**RE: SITE PLAN CONTROL  
788 March Road, Kanata  
S+A PROJECT # 18664.000**

The following is our response to the comments made by the City of Ottawa with respect to Site Plan Control Approval, first round comments.

### ***Item 2.B37***

Drawing file: plan / All_Image Referencing_Site Plan Application_Image Reference_2019-01-14 Stormwater Management Plan D07-12-18-0128.PDF

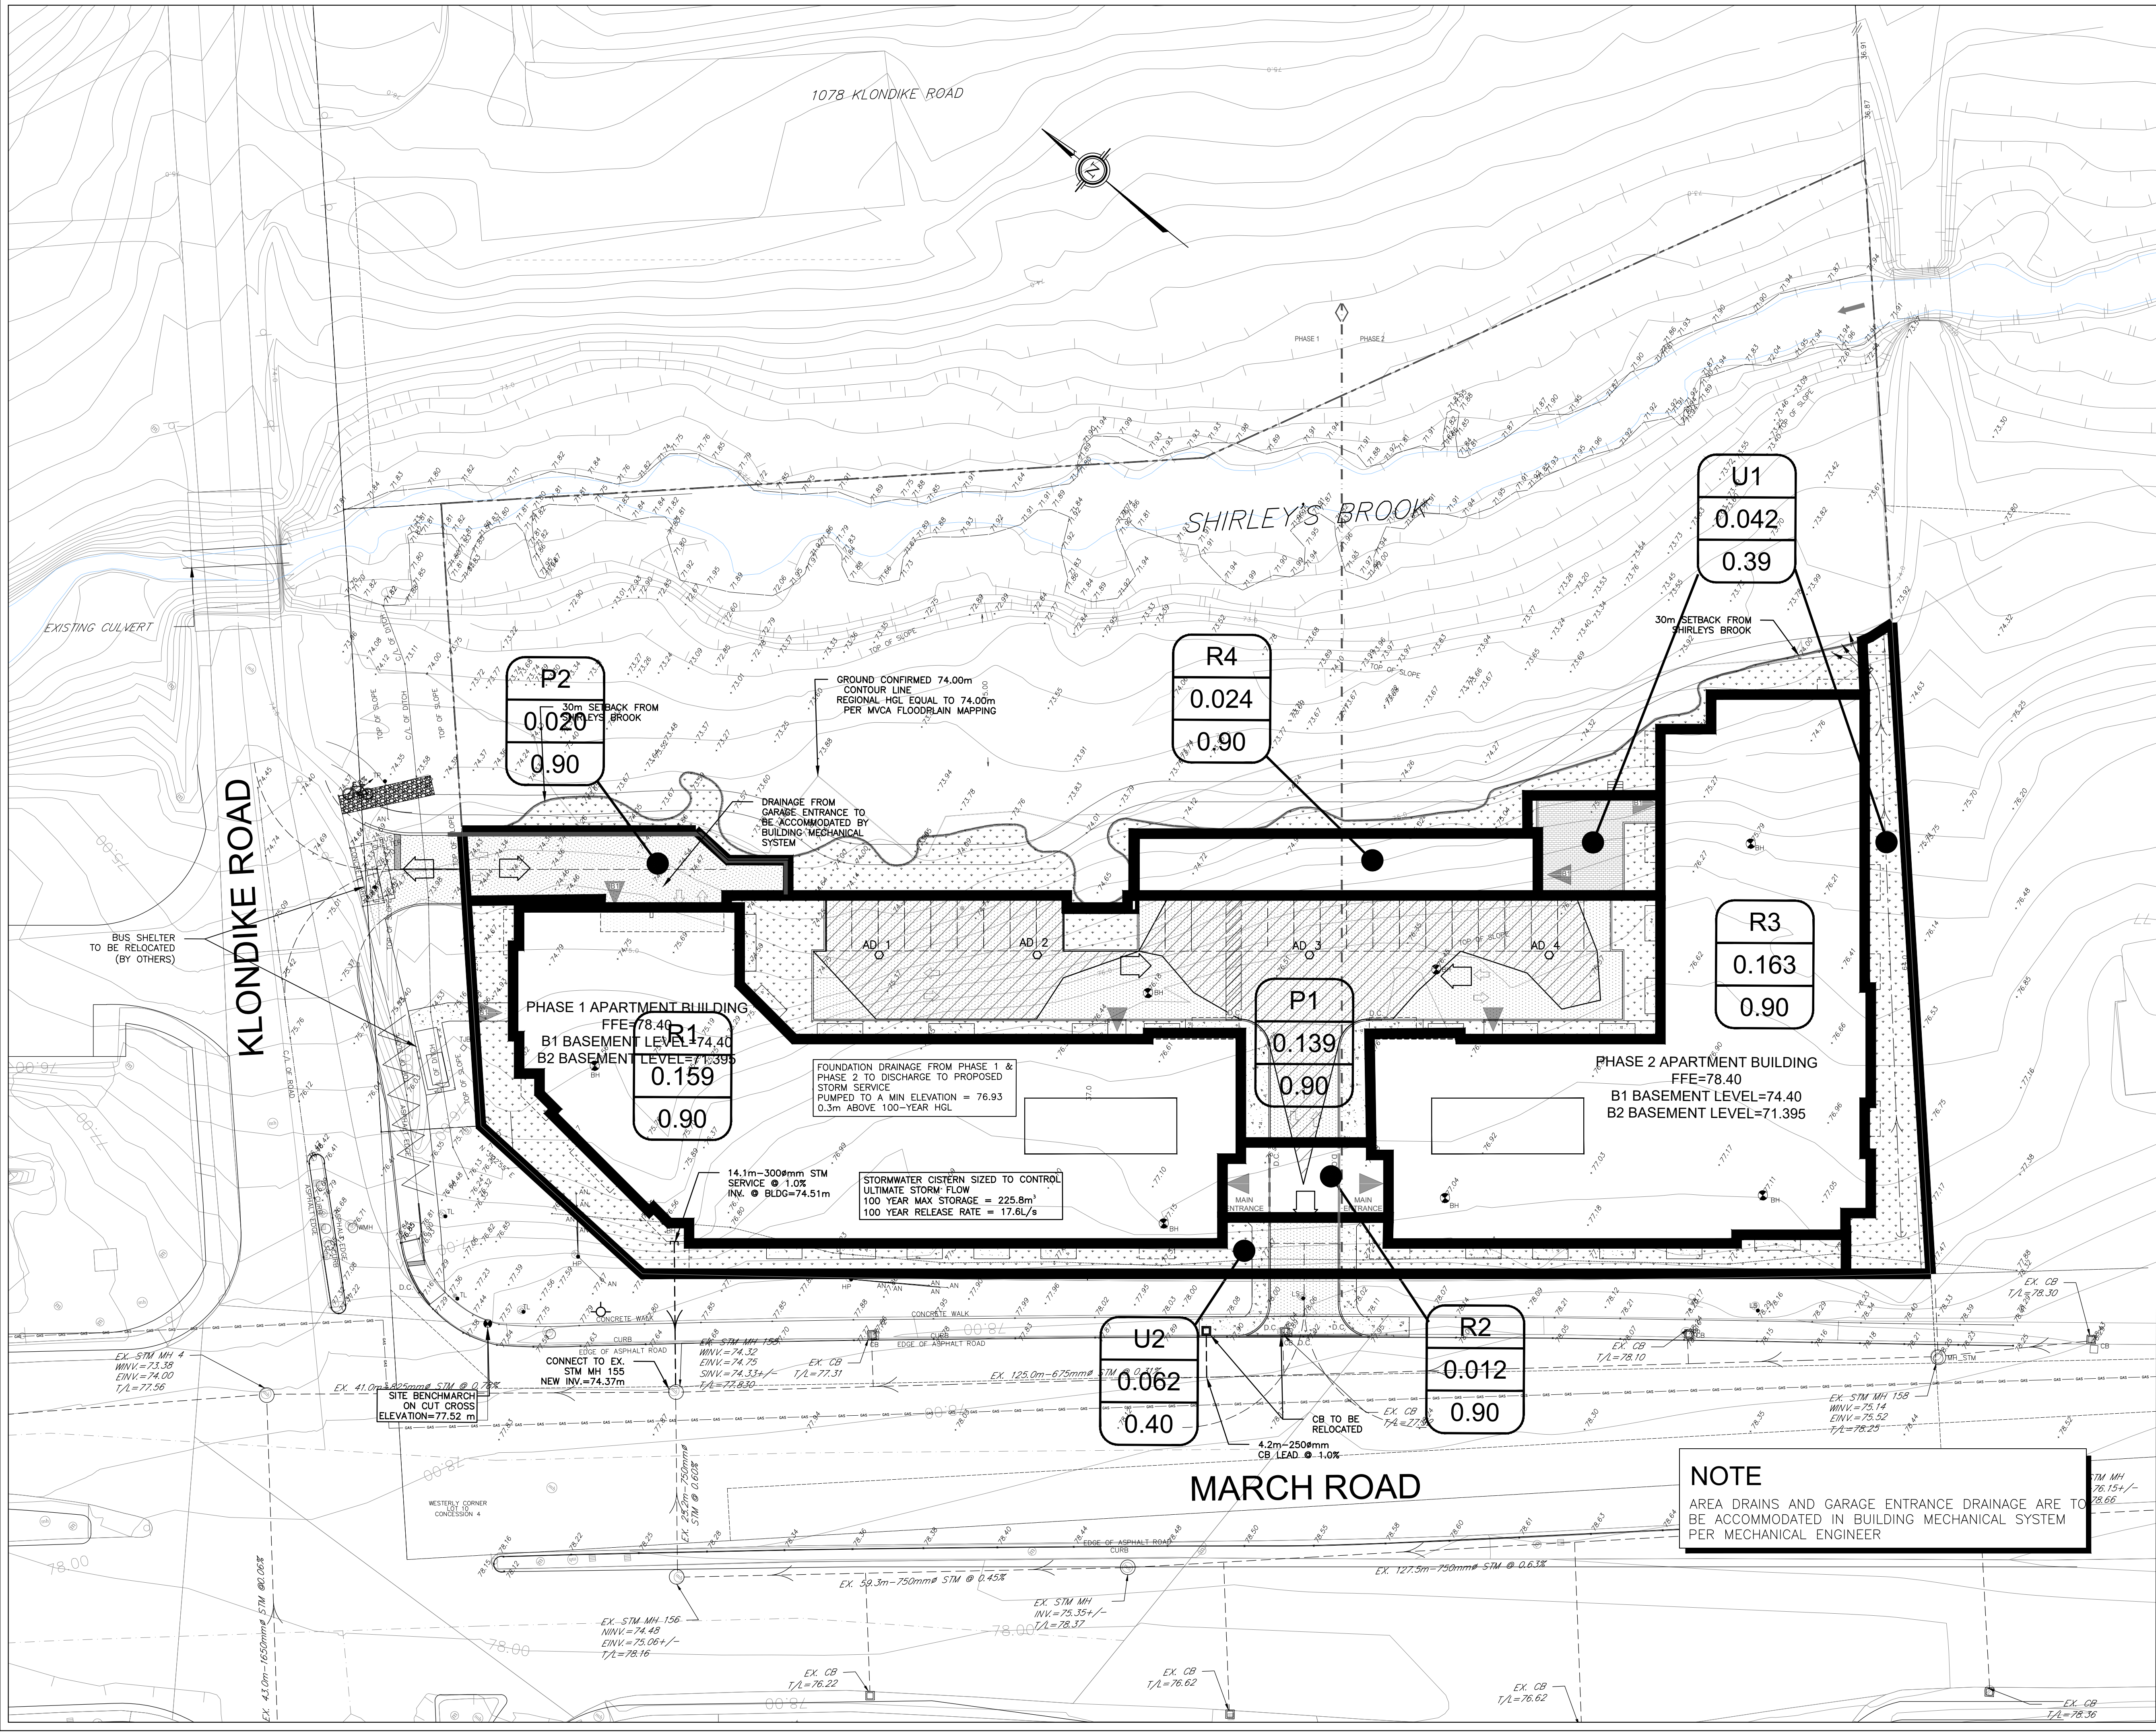
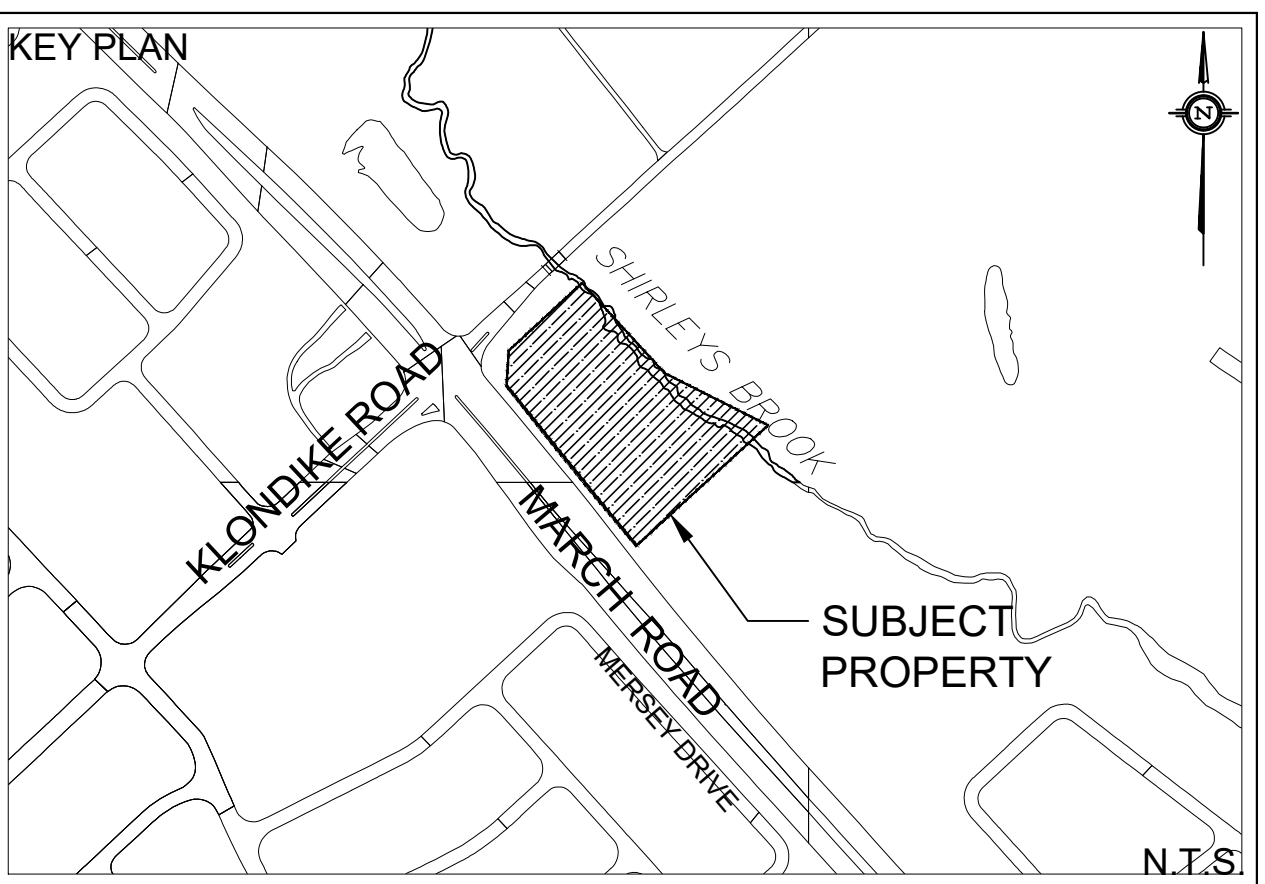
*Provide correspondence from the Mechanical Engineer that the roof drains and area drains will be designed to capture up to the 100-year storm event, as stated in the Functional Serving and Stormwater Management Report.*

**Roof drains, area drains, and parking garage trench drain shall be designed as uncontrolled flow to capture a 100 year storm event flow rates as per DSEL Stormwater Management Plan SWM-1. Flow rates per drain, and drain sizing will be developed for the City Permit submission.**
